Engineers Comments Regarding Surface Water Drainage

Application Reference:	BN/110/25/DOC	Reviewer Reference:	EXT2
Planning Officer:	Hannah Kersley	Date of Review:	18/11/2025
Site Name:	Land South of Barnham Station Barnham		
Application Description:	Approval of details reserved by condition imposed under BN/142/20/OUT relating to conditions 6-surface water drainage and 8-maintenance and management of surface water drainage scheme.		
Assessment Number:	2 of 2

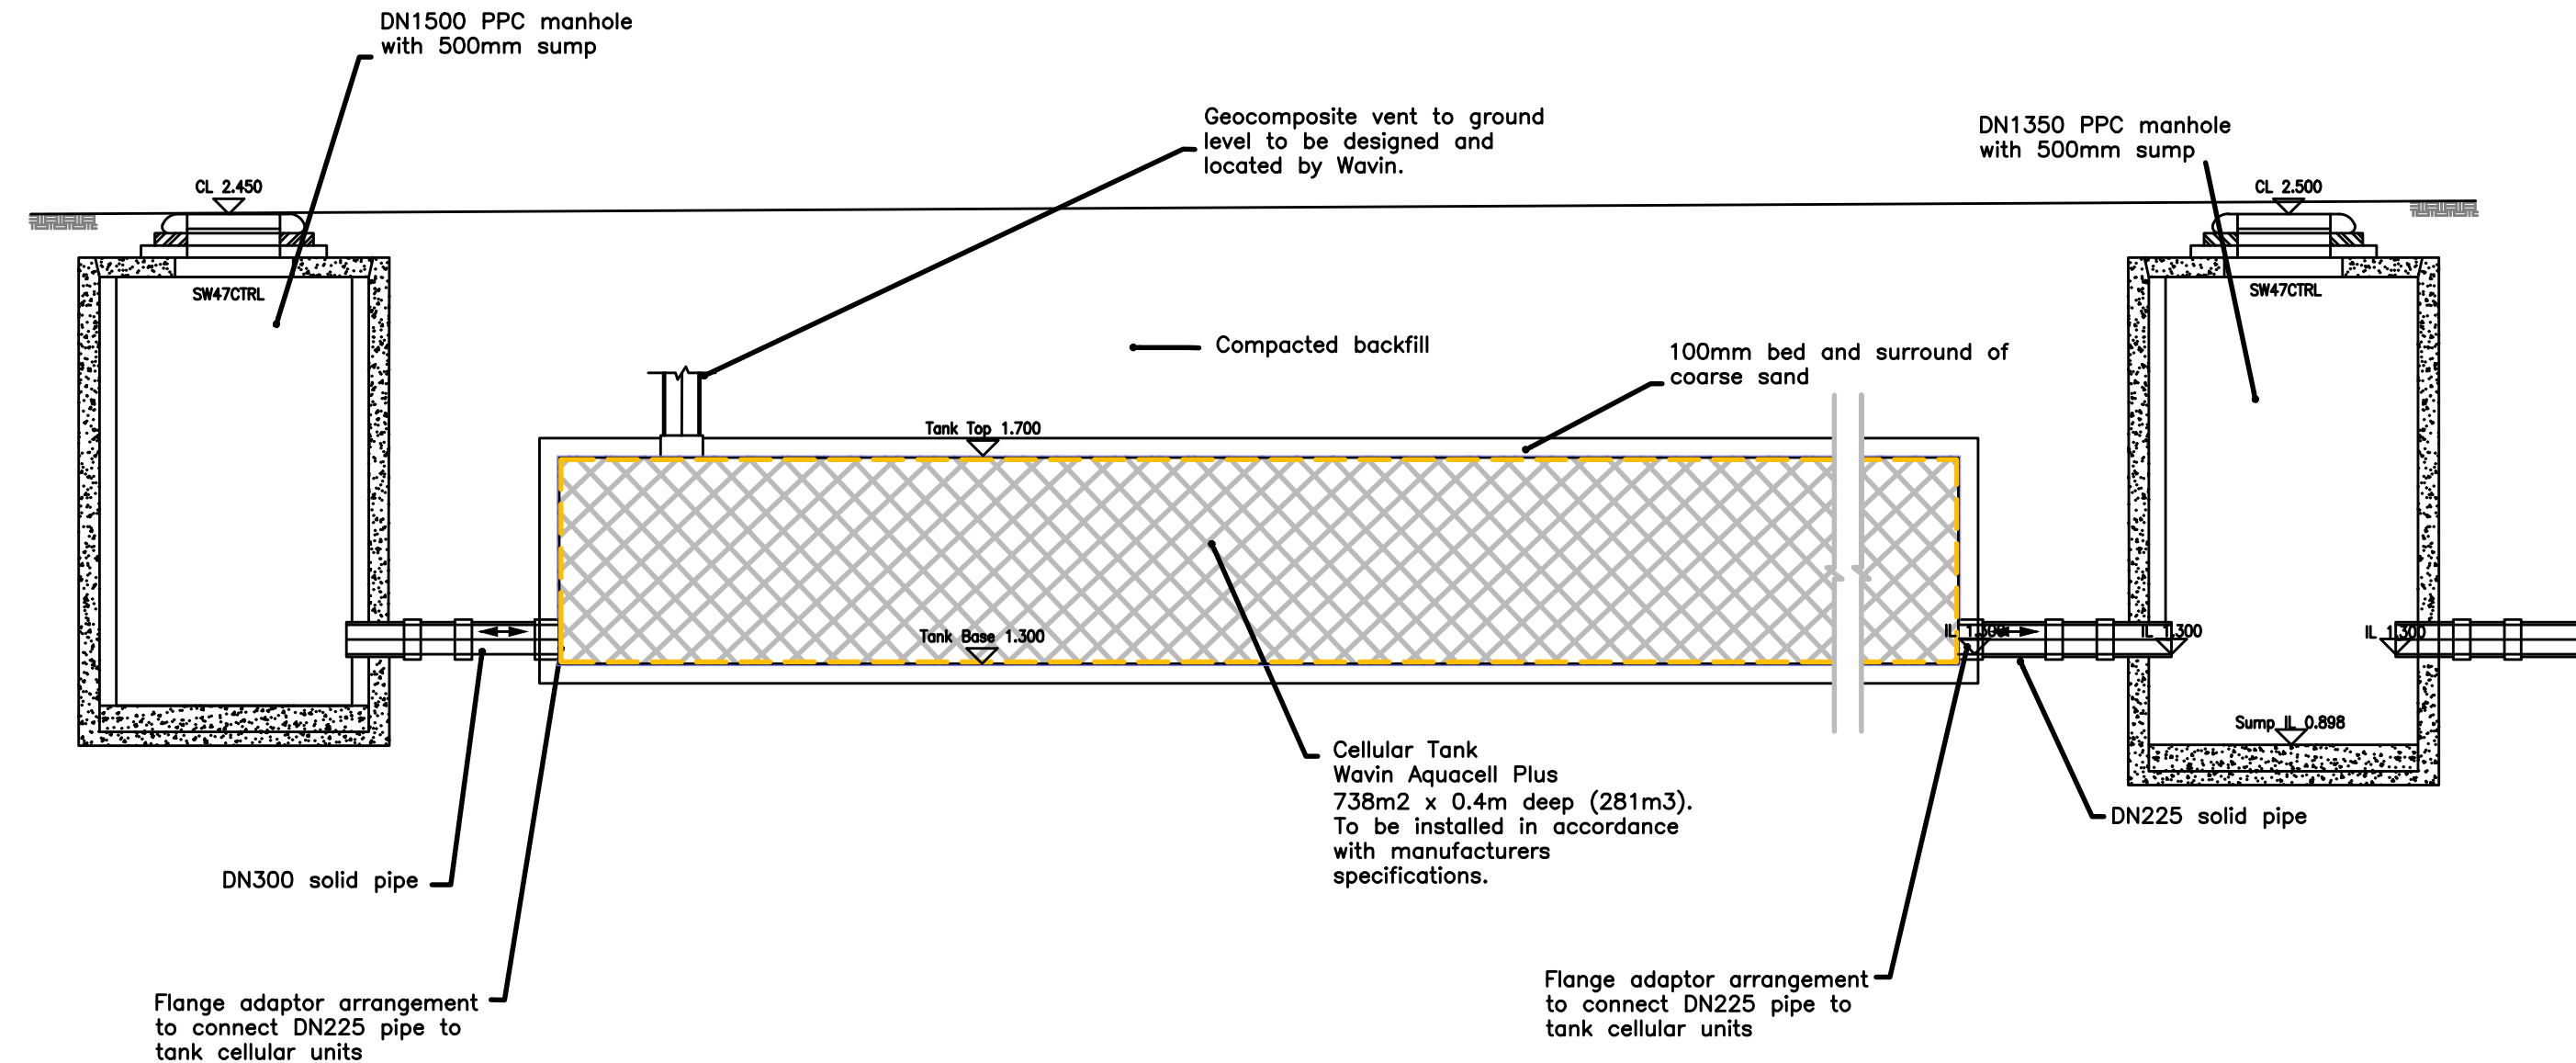
The hydrobrake part reference has now been added to each control and on the engineering plans.				
8. (formally 10)	ADC Further Comments [BN/52/24/DOC] 12/06/2024: The surface water manhole schedule is not consistent with the details in the microdrainage calculations and the overall engineering layout Designer Response [BN/98/24/DOC] 24/07/2024: Schedule now consistent with calcs and layout. Refer to MJA plan 6838-MJA-SW-XX-DR-C-700 P4 ADC Response [BN/98/24/DOC] 03/10/2024: Spot check on SW40, SW41 and SW34 concludes that are still inconsistencies between the manhole schedules/calculations and the overall drainage layout. ADC Drainage Comments [BN/157/24/DOC] 29/04/2025 The manhole schedule is not consistent with the plan. Eg. SW14, SW15 and SW17(CP) cover levels. There are also a number of chambers where the type is incorrectly specified. Eg. control chambers specified as catchpits and Downstream defender chambers specified as standard manholes. Designer Response [BN/157/24/DOC] 16/06/2025 We believe these are all now consistent. Refer to MJA dwg 6838-MJA-SW-XX-DR-C-705_T6 These have been corrected. Designer Response [BN/98/24/DOC] 21/11/2024 Calcs, Schedules and Layouts now all match ADC Drainage Comments [BN/157/24/DOC] 16/01/2025	Drawing 6838-700 P3 has been included in the submission and shows different information to drawings 6836-703 P4 and 705 T6. Should drawing 700 P3 be withdrawn? There are still many chambers where the cover type is not specified on the drawings. SW08 is specified as non-standard 1575mm diameter on drawing 703 P4	Note that both 700 & 703 are superseded by drawing number 705. Please refer to MJA drawing 705 Rev T8 MH Schedule which picks up issues highlighted for point 8.	There are inconsistencies between the manhole schedules and drawing 210-C1. See comment 34

9. (formally 11)	ADC Further Comments [BN/52/24/DOC] 12/06/2024: Flow control chambers and catchpits are noted as standard manhole types on the manhole schedule. Designer Response [BN/98/24/DOC] 24/07/2024: ADC Response [BN/98/24/DOC] 03/10/2024: This can be closed when Item 8 (formally 10) is concluded Designer Response [BN/98/24/DOC] 21/11/2024 N/A Designer Response [BN/157/24/DOC] 17/02/2025 Noted ADC Drainage Comments [BN/157/24/DOC] 29/04/2025 See comments 8 Designer Response [BN/157/24/DOC] 16/06/2025 These have been corrected	As comment 8	Please refer to 705 Rev T8 MH Schedule which picks up issues highlighted.	There are inconsistencies between the manhole schedules and drawing 210-C1. See comment 34

34. (formally 42)	ADC Response [BN/98/24/DOC] 03/10/2024: Please provide the detailed design prepared by SDS Ltd noted on drawing 210. Designer Response [BN/98/24/DOC] 21/11/2024 Tank type changed to Wavin Aquacell. Construction drawings will be issued by Wavin upon receipt of	Whilst a description has been provided for connecting 225 diameter pipes to the storage tank,	Please refer to drawing 210_C1 which shows construction detail of tank and notes the inclusion of a flange adaptor arrangement	Drg 210-C1: Tank 1 Outlet is noted as 300 diameter and 225 diameter

Tank 2 Chamber diameters are different to schedule HD1CTRL IL shown on pipe is different to schedule and above tank base HD1 drawn as catchpit but it is a flow control chamber Detail regarding vent unclear. More detail required.	
35.	ADC Drainage Comments [BN/157/24/DOC] 16/01/2025 A statement is included in the submitted Technical Note regarding water quality but no evidence is provided to demonstrate compliance with the various documents listed. Please demonstrate compliance. Designer Response [BN/157/24/DOC] 17/02/2025 Can you please clarify what additional evidence you need to demonstrate compliance?	Additional information provided. Comment closed.

order. ADC Drainage Comments [BN/157/24/DOC] 16/01/2025 Please provide the detailed design referred to on the drawing. Designer Response [BN/157/24/DOC] 17/02/2025 MJA drawing 6838-MJA-SW-XX-DR-C-210_P5 is sufficiently detailed to tender and construct from. Note on drawing amended to 'To be constructed in accordance with manufacturers installation specifications.' ADC Drainage Comments [BN/157/24/DOC] 29/04/2025 The status of this drawing is preliminary making it subject to changes. Please provide a Construction Issue drawing. Details must be provided of how larger diameter pipes will be connected to the product, which have 150mm diameter preformed connectors. If this requires a manifold of multiple 150mm diameter pipes, this must be reflected in the calculations and shown on drainage plan Designer Response [BN/157/24/DOC] 16/06/2025 A Flange Adaptor can be used to connect up to a DN225 pipe to the aquacell unit. The DN300 pipe linking Tank 1 to SW47CTRL has been reduced to a DN225 pipe and calcs updated to suit.	the drawings have not been updated to communicate this to the contractor. A detail must be provided on the drawings.	to facilitate the DN225 pipe connection to the cellular tank.	Both chambers noted as SWCTRL47 (should there only be 1 chamber?) SW47CTRL drawn as catchpit but its a flow control chamber Chamber diameter is different to schedule IL on pipe not readable Sump level of 0.898 appears to be incorrect (not consistent with 500mm deep sump) Detail regarding vent is unclear. More detail required.
